STATE OF NORTH CAROLINA  
DEPARTMENT OF TRANSPORTATION

**Addendum No. 1**

**Cabarrus County (B-5808)**

BRIDGES #57 AND #59 OVER IRISH BUFFALO CREEK ON US-29 AND US-601.

**NOTE:**  
 ALL UTILITY WORK SHOWN ON THIS SHEET WILL BE DONE BY OTHERS. NO PAYMENT WILL BE MADE TO THE CONTRACTOR FOR UTILITY WORK SHOWN ON THIS SHEET.

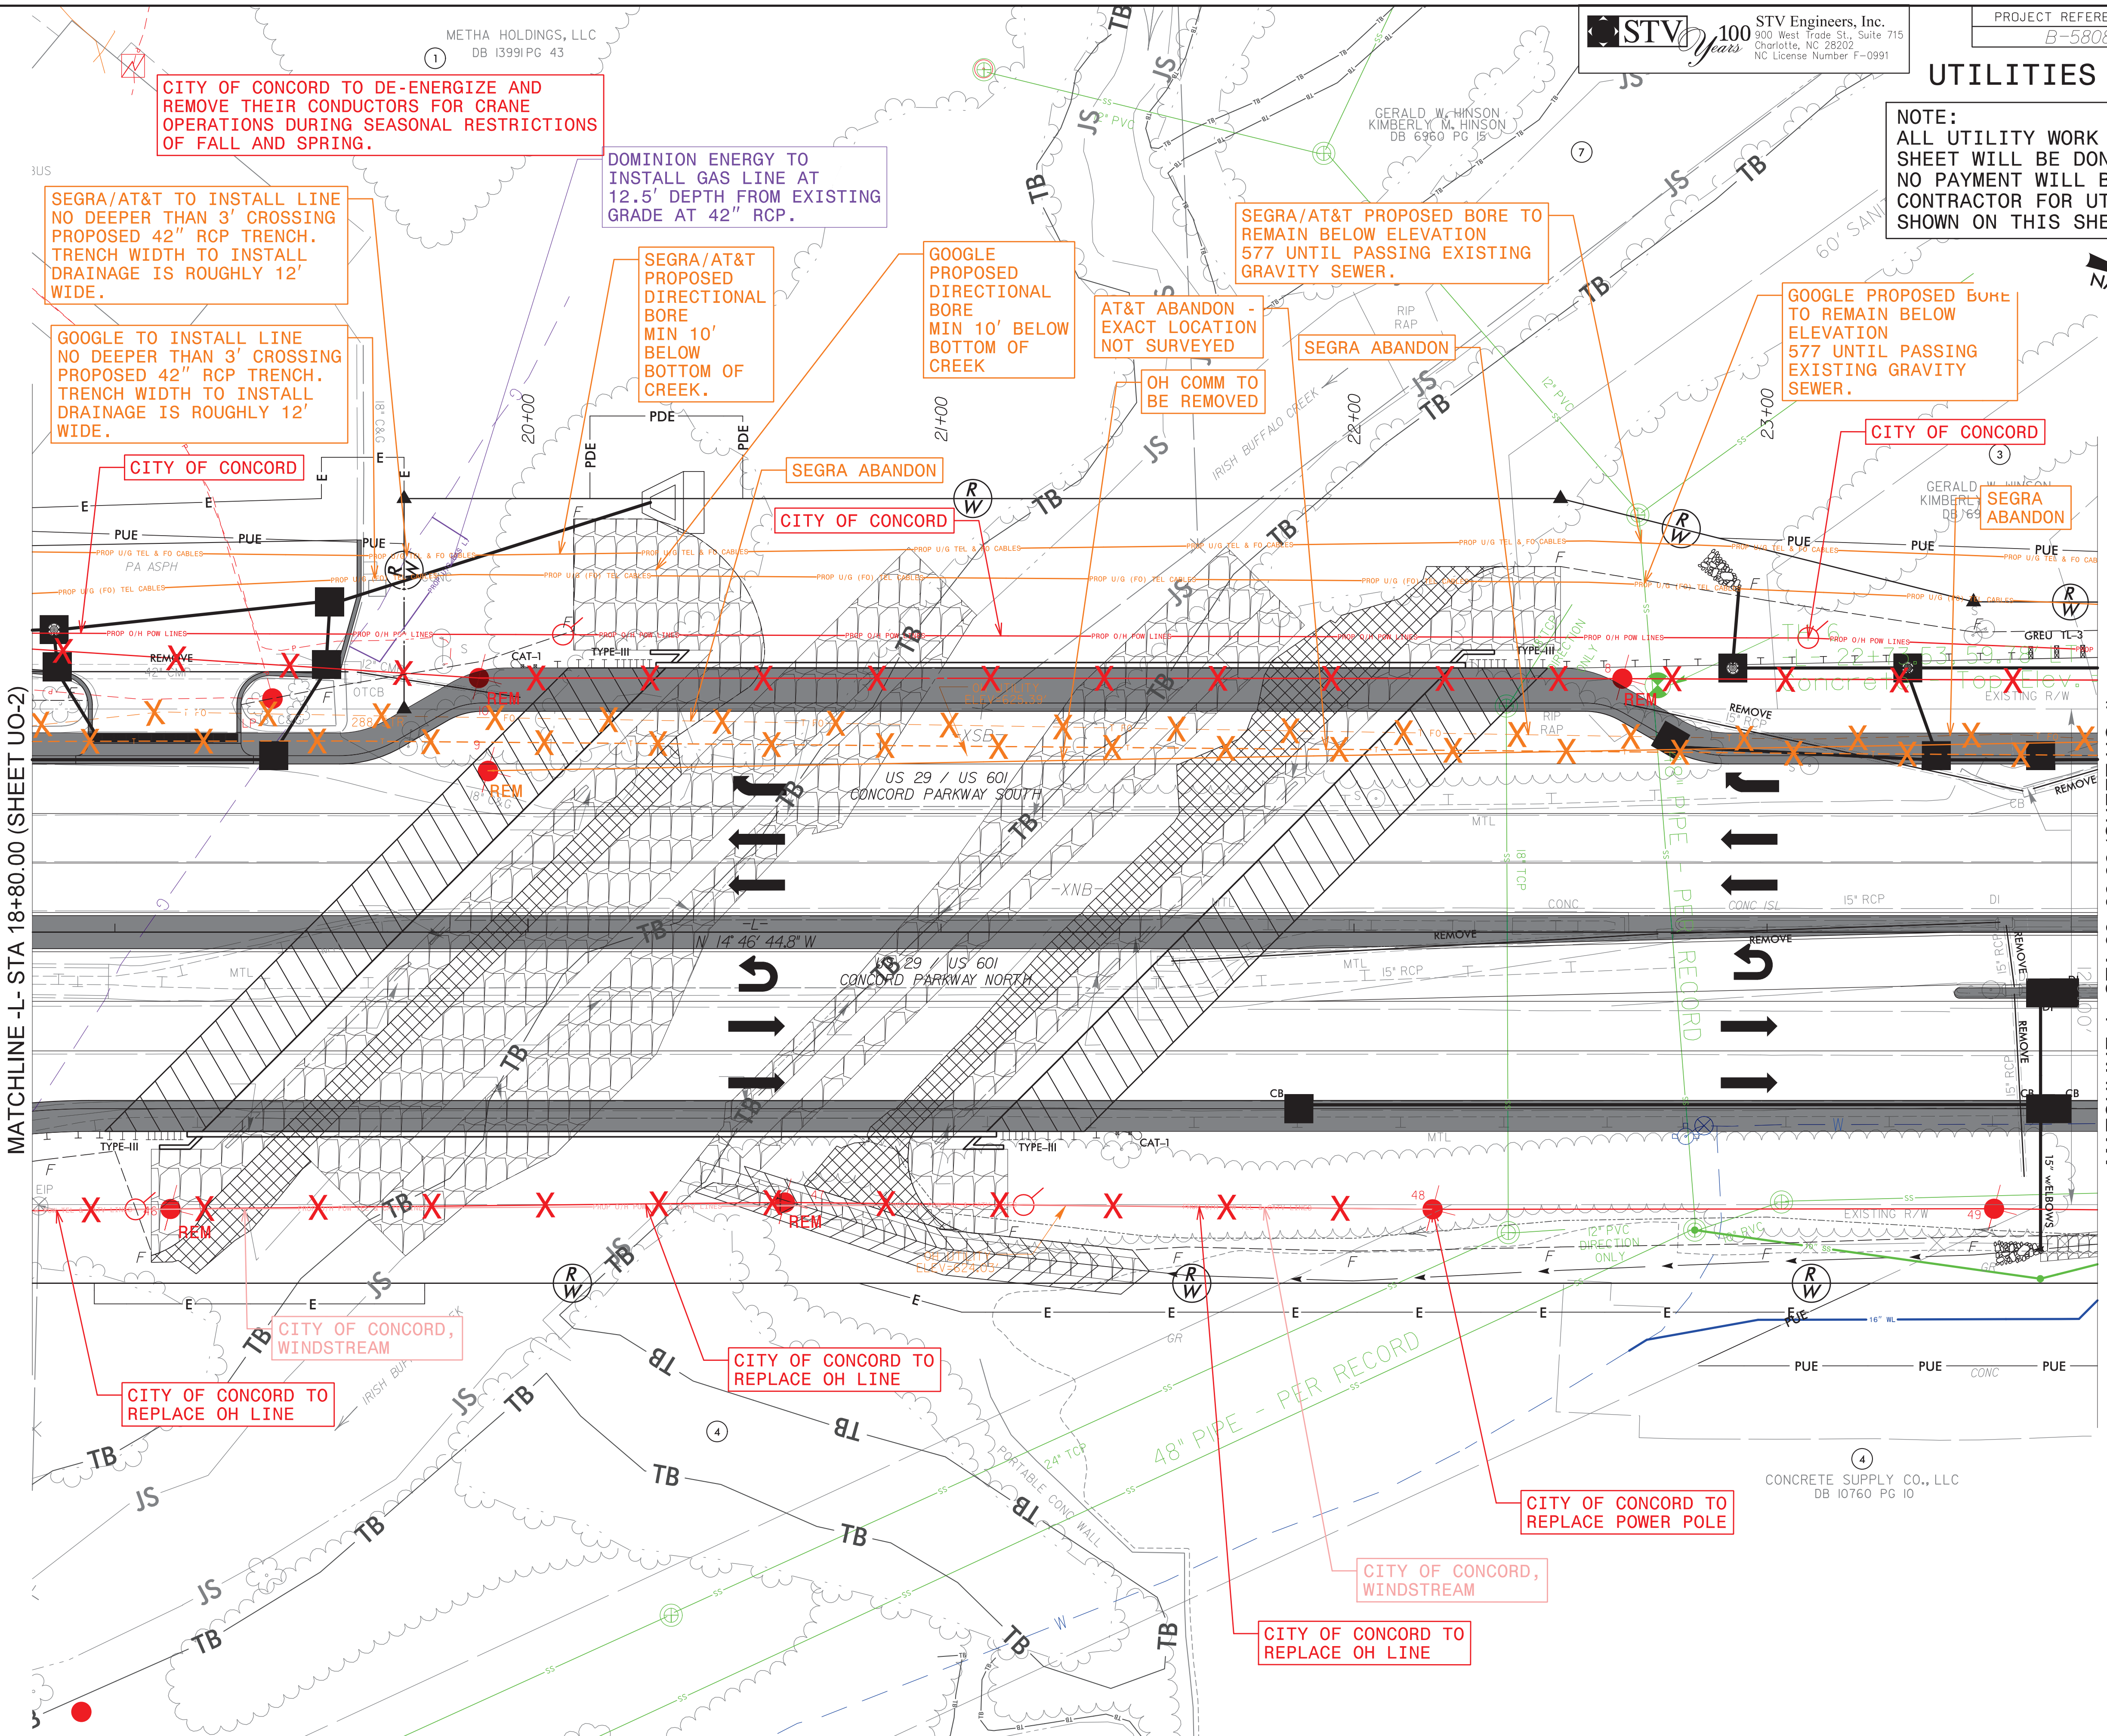
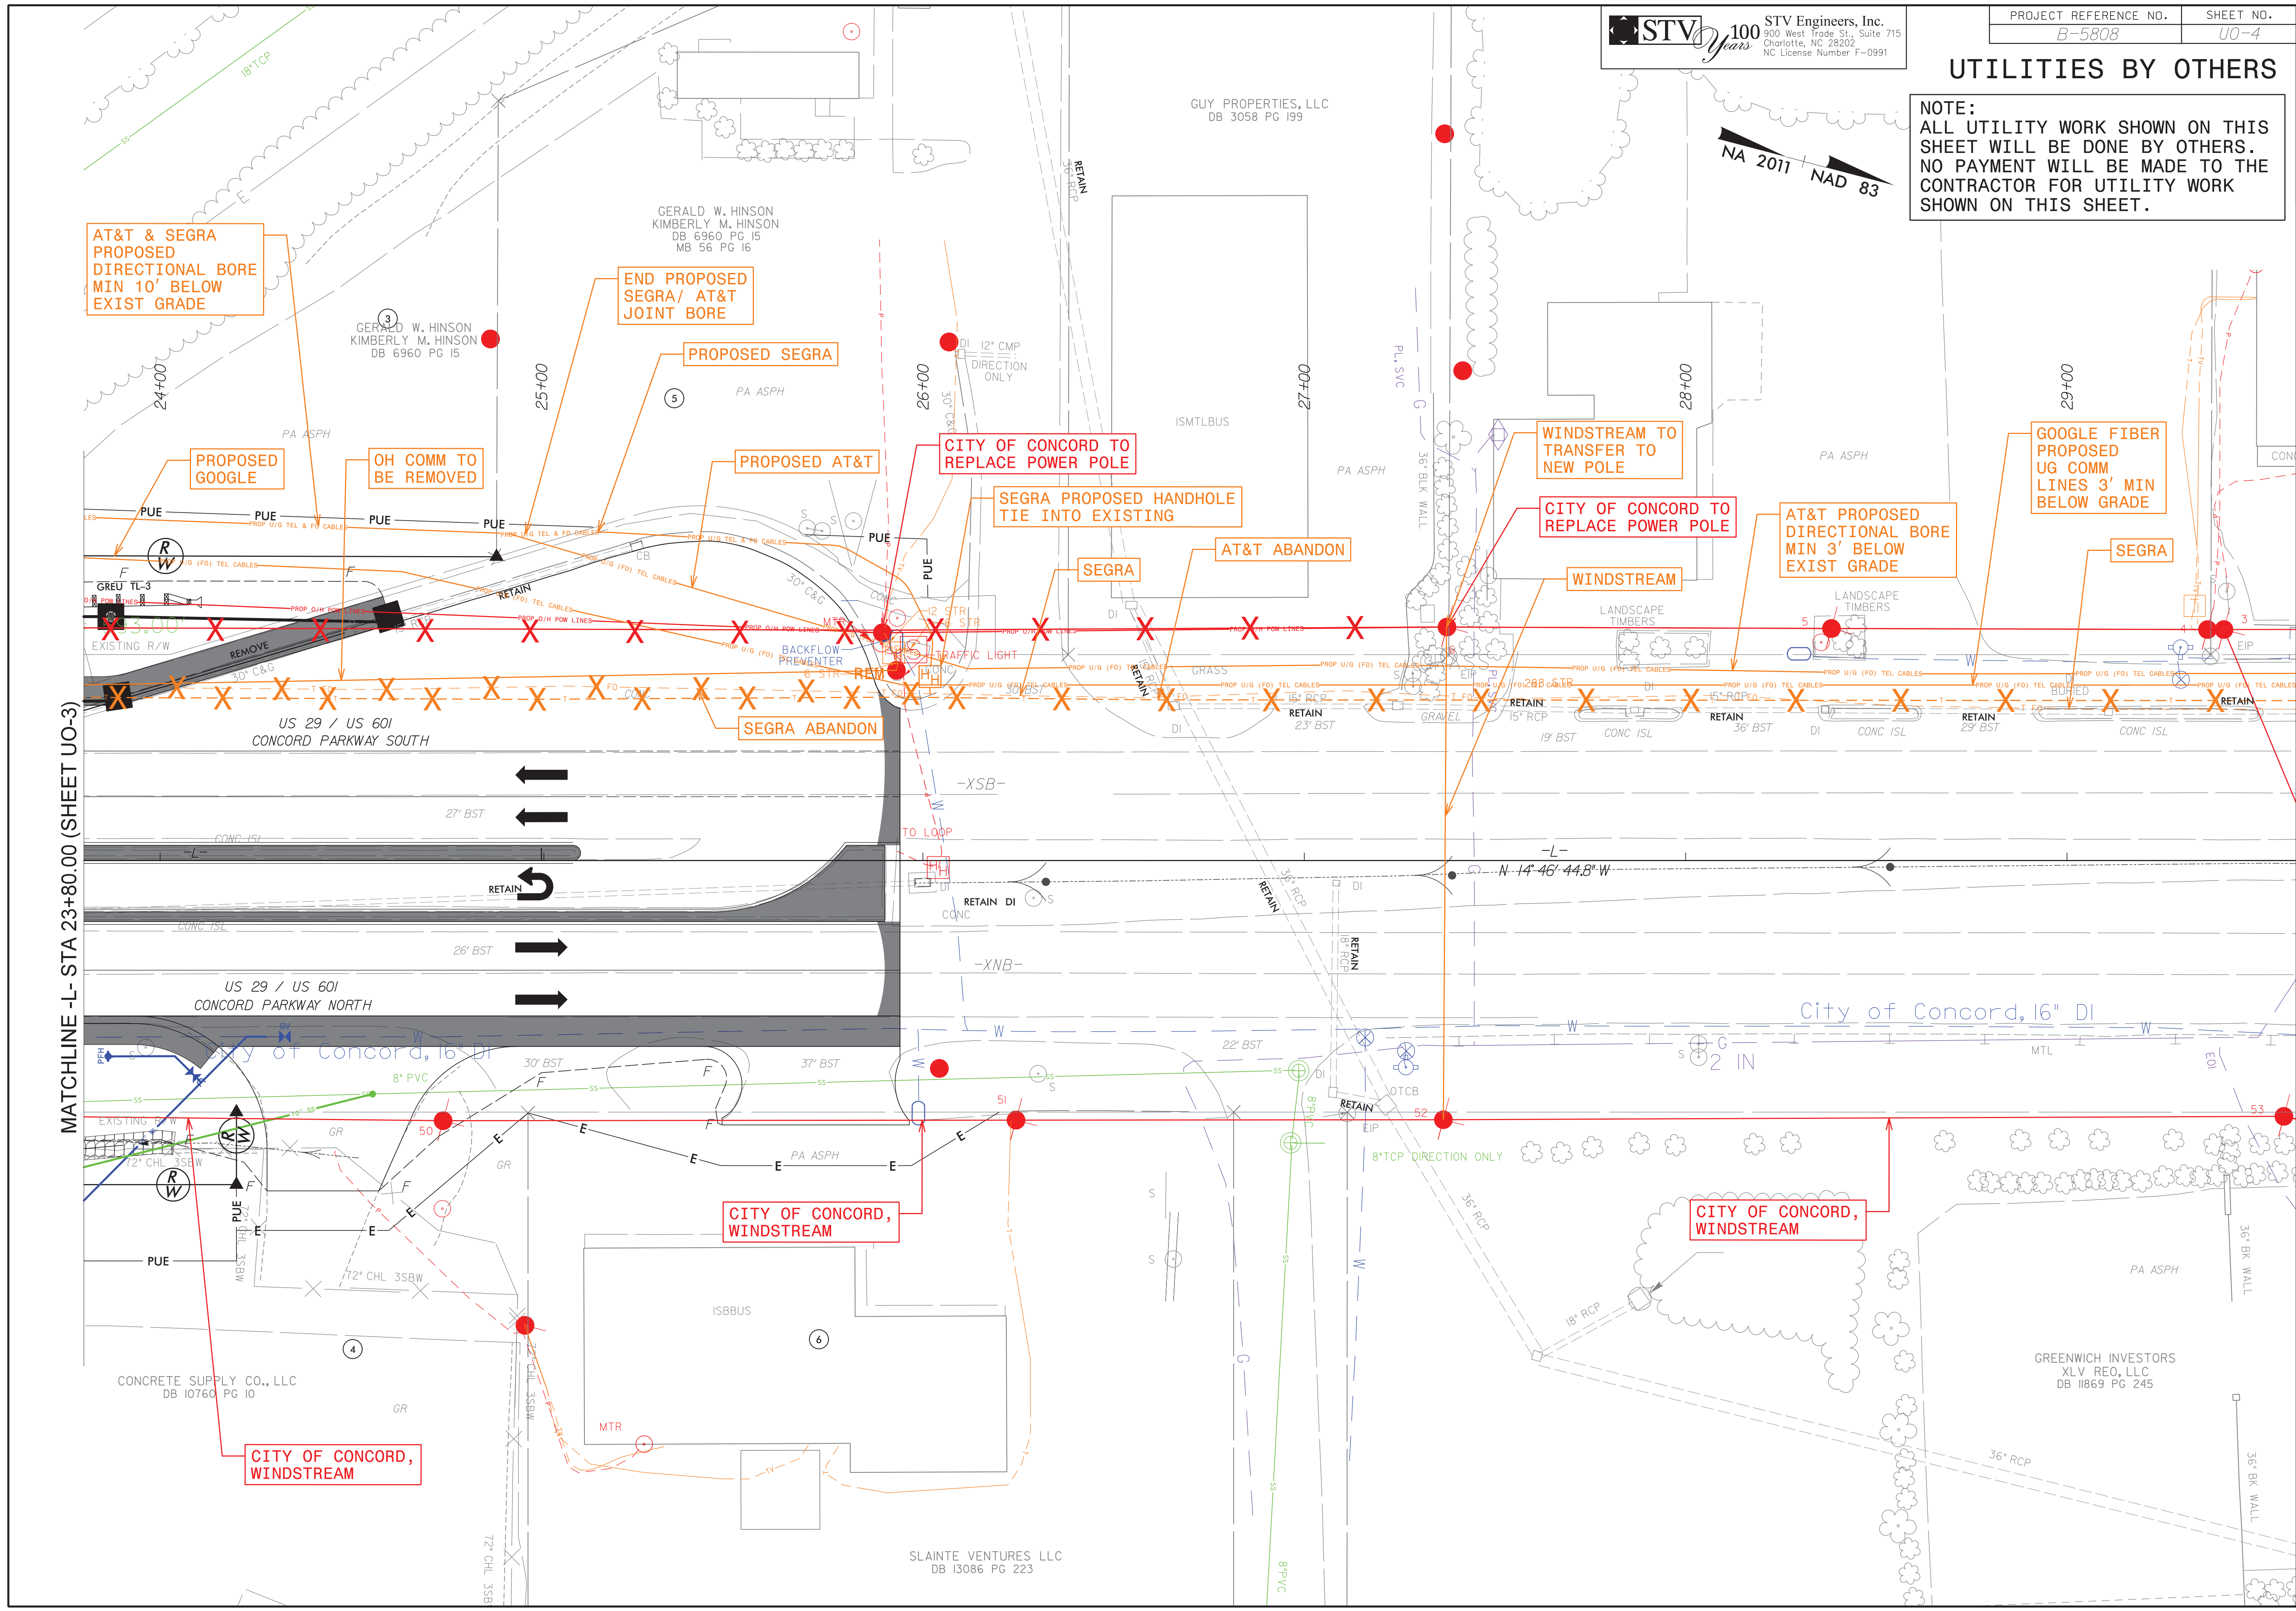
Sheet No.	Revision
UO-1 thru UO-4	Sheets revised to include Google Fiber.

- 1) Google will install their underground facilities on the north side of Poplar Tent Road, cross under US 29/US 601 at a minimum depth of 15 feet, and tie back to their existing facilities on McGill Avenue outside the project limits. Google also plans to install an underground fiber on the west side of US 29/US 601. They plan to be 3 feet deep at the 42-in drainage crossing, so the contractor will coordinate with them during that drainage installation. This is all new construction, so no completion date has been finalized.
